Somerset House
High Street
Angmering
Littlehampton
West Sussex
BN16 4AG
20th February 2014.

Ref A/2/14 and A/3/14L Angmering Manor Hotel, Angmering.

PROPOSED CAR PARK LAYOUT

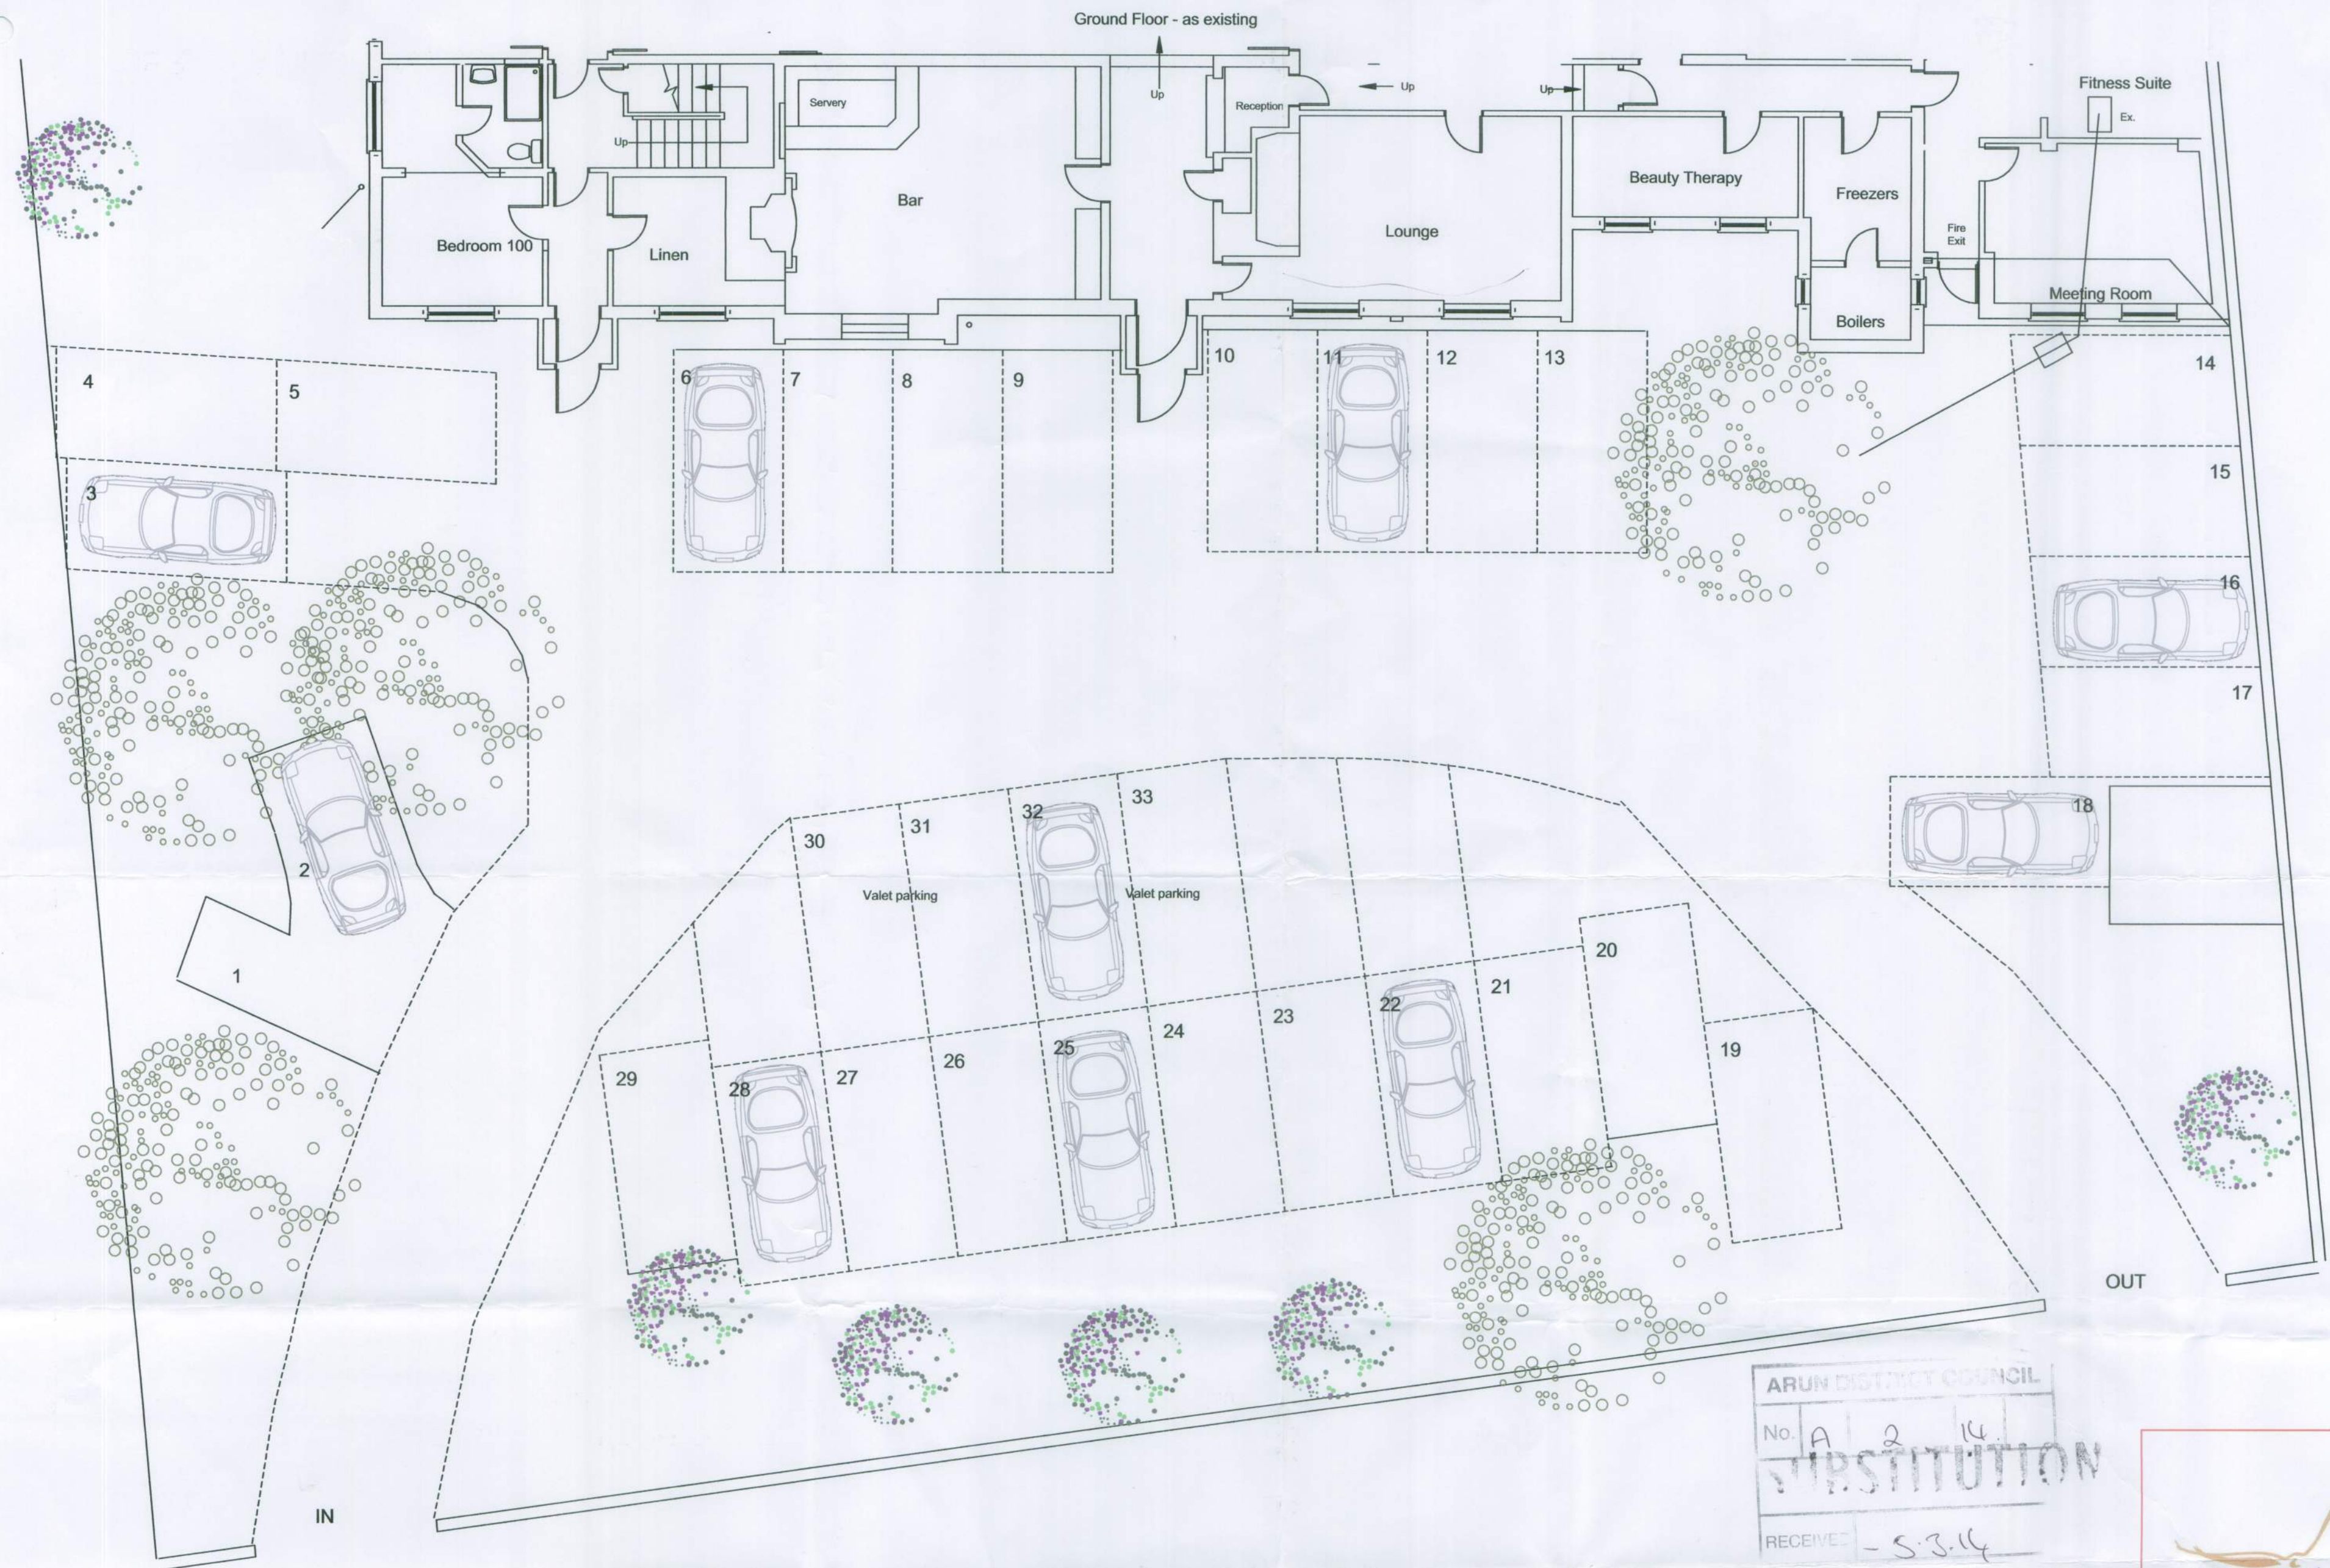
Parking on site can only be practical for a little over 20 cars. The claimed on site parking for 35 cars is ridiculous and will never be obtained for hotel business. The hotel offers three dining areas with a maximum guest number of 80 covers. There is also a health spa and treatment centre, 17 – 19 rooms all of which are rarely if ever used, a bar and enough staff to service this business. It is obvious parking has to be a major problem and High Street is constantly used for parking by visitors and staff.

Title
ADDITIONAL GARDEN BEDROOMS
ELEVATIONS

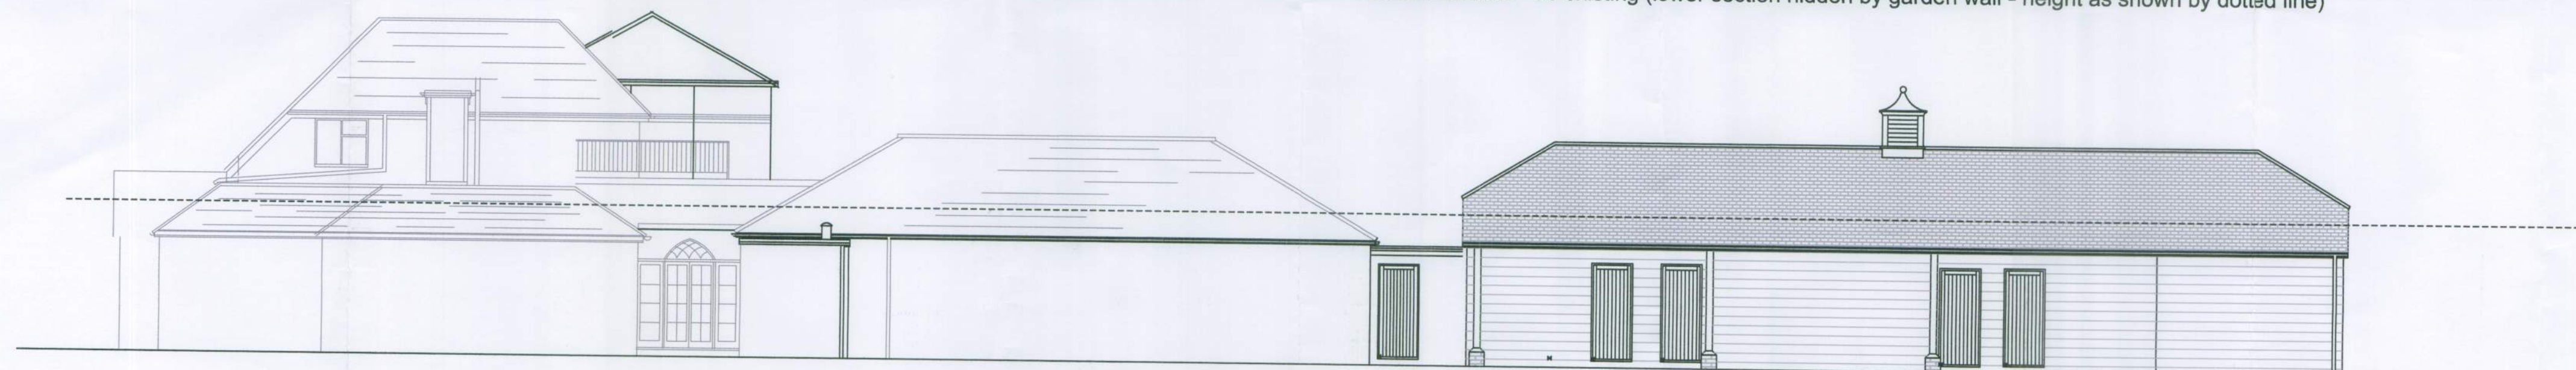
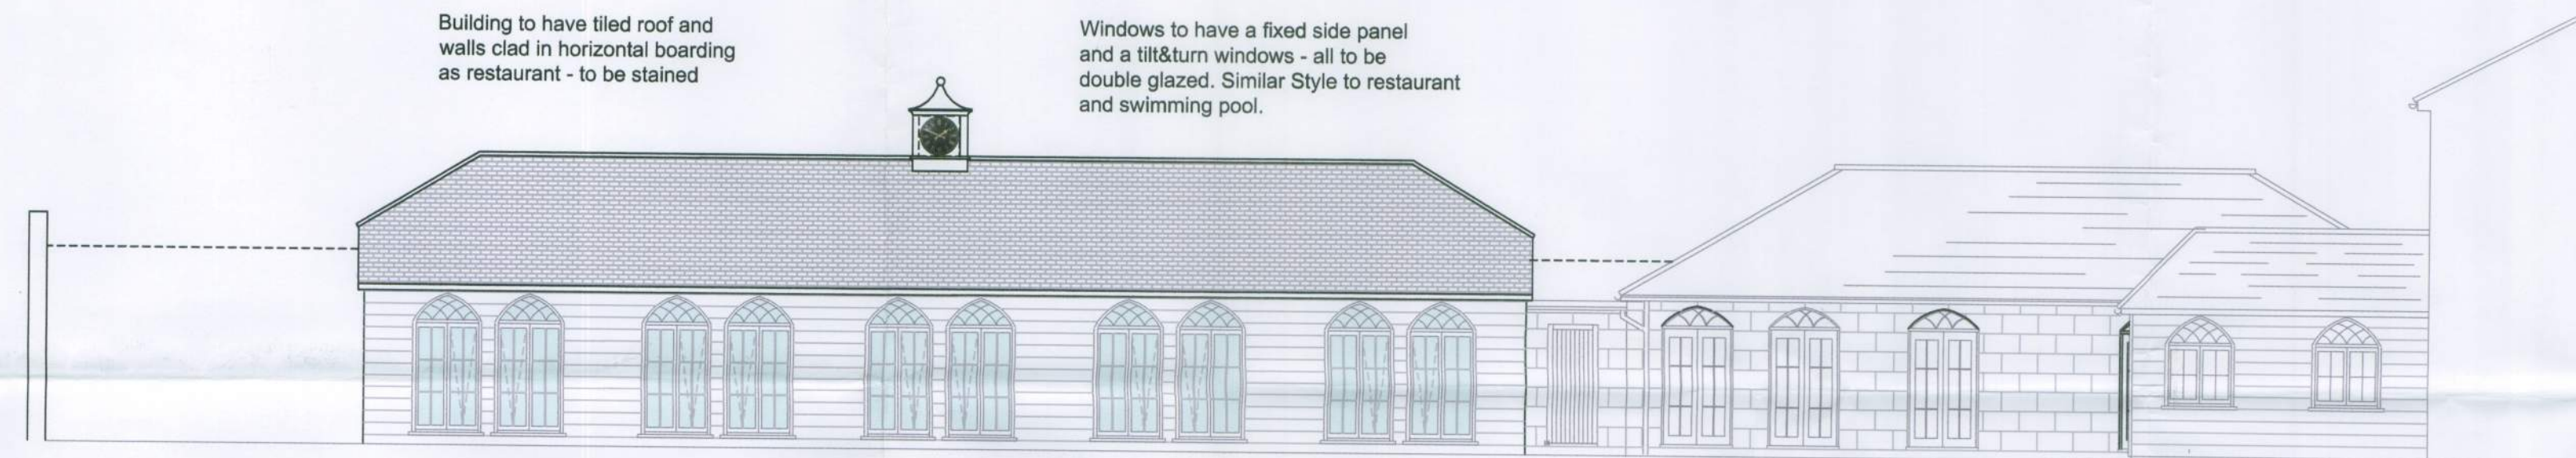
The new position for 5 bedrooms is no improvement over previous applications. An existing condition forbids amplified noise in this area and it will be impossible to manage noise from these rooms from both front and rear. The proximity of shared boundaries with adjoining

properties will seriously affect these properties. I note there is an uncovered path to these rooms along the boundary wall.

Additional building on this site can only compromise the integrity of this old historically interesting building.
